From: BCTAdmin@thameswater.co.uk
To: [Planning](#)
Subject: 3rd Party Planning Application - 6/2019/1788/COND
Date: 19 November 2019 10:20:41

Our DTS Ref: 26322
Your Ref: 6/2019/1788/COND

Re: FORMER SHREDDED WHEAT FACTORY, BRIDGE ROAD, WELWYN GARDEN CITY,
HERTFORDSHIRE, AL8 6UN

Thank you for consulting Thames Water for the discharge of matters relating to SURFACE WATER. Thames Water are unable to support the discharge of this condition for the reasons outlined below.

PROPOSED DRAINAGE LAYOUT (PHASE 1)

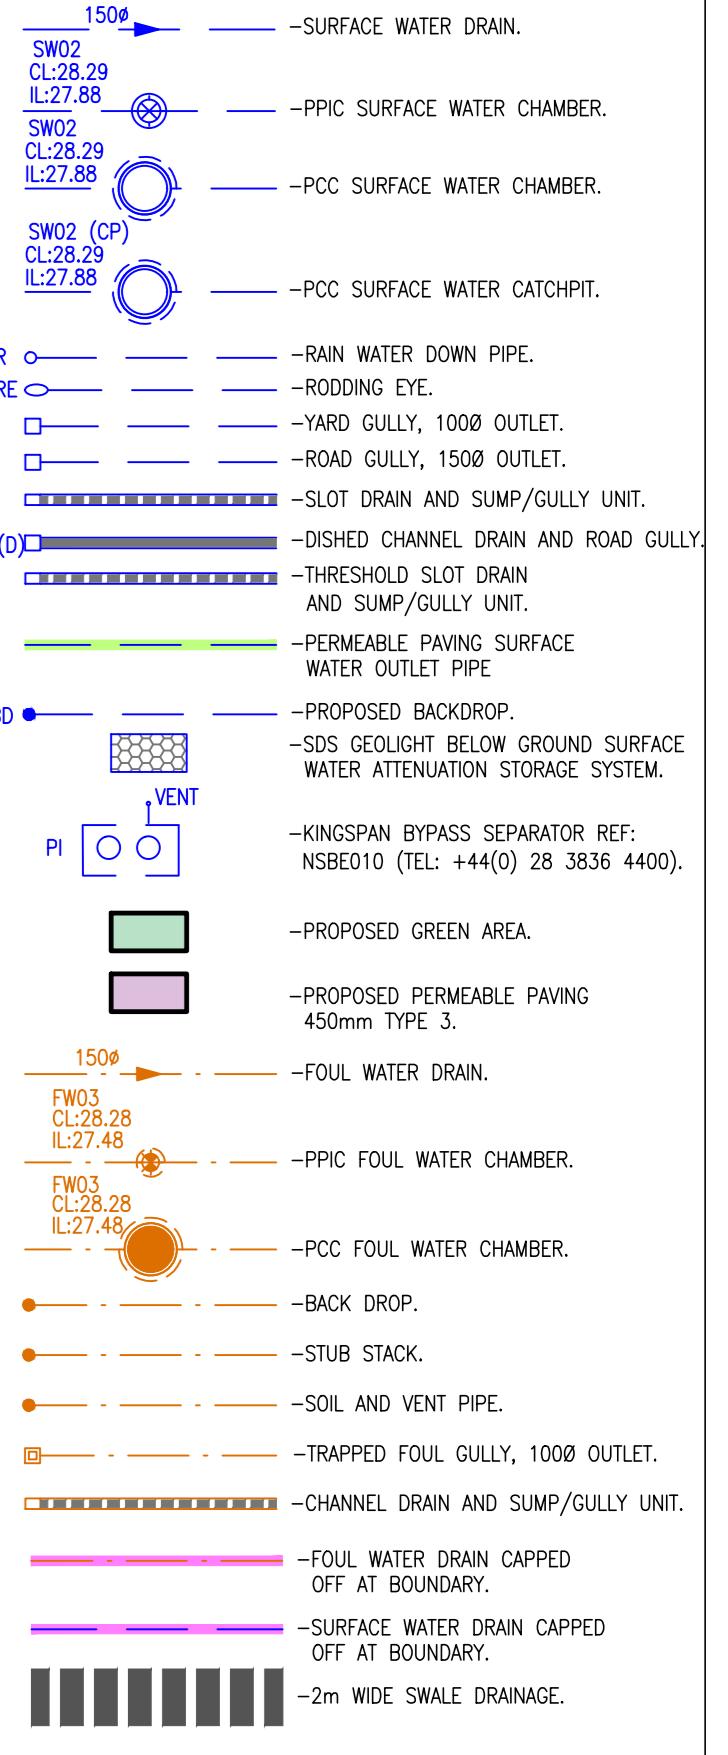
The strategy lacks detail only calculations which don't articulate the intended flows etc. Give a brief description of volumes, discharge rates say 1:1, 1:10, 1:30 and 1:100. Also show and give capacity of any attenuation.
